August 25, 2022

County File: OAR289 (Wrong file prefix, was reviewed as an ANX)

Re: RMG - Town of Monument

1 SITE DEVELOPMENT PLAN
SCALE: 1" = 30'-0"

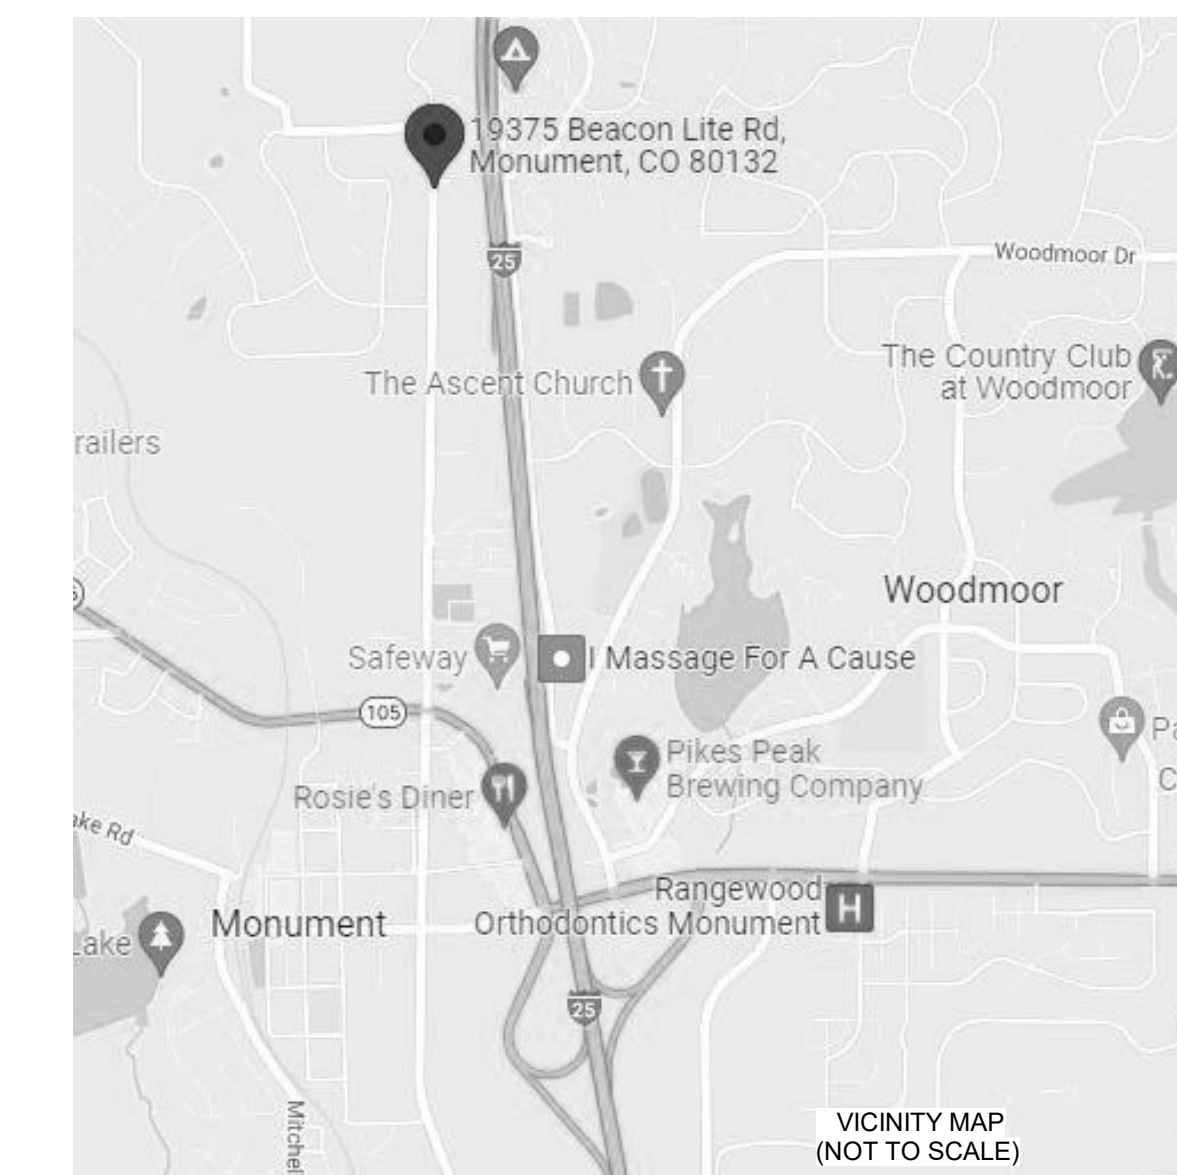
1. County access permitting will address any right-of-way and construction requirements for Beacon Lite Road. The proposed second access shown on the Concept Plan does not meet County criteria.
2. A traffic impact study and construction drawings will need to be reviewed and approved by EPC for improvements to Beacon Lite Road if it remains under County jurisdiction.
3. Note: Work-in-the-right-of-way permits are required for construction in the County right-of-way.
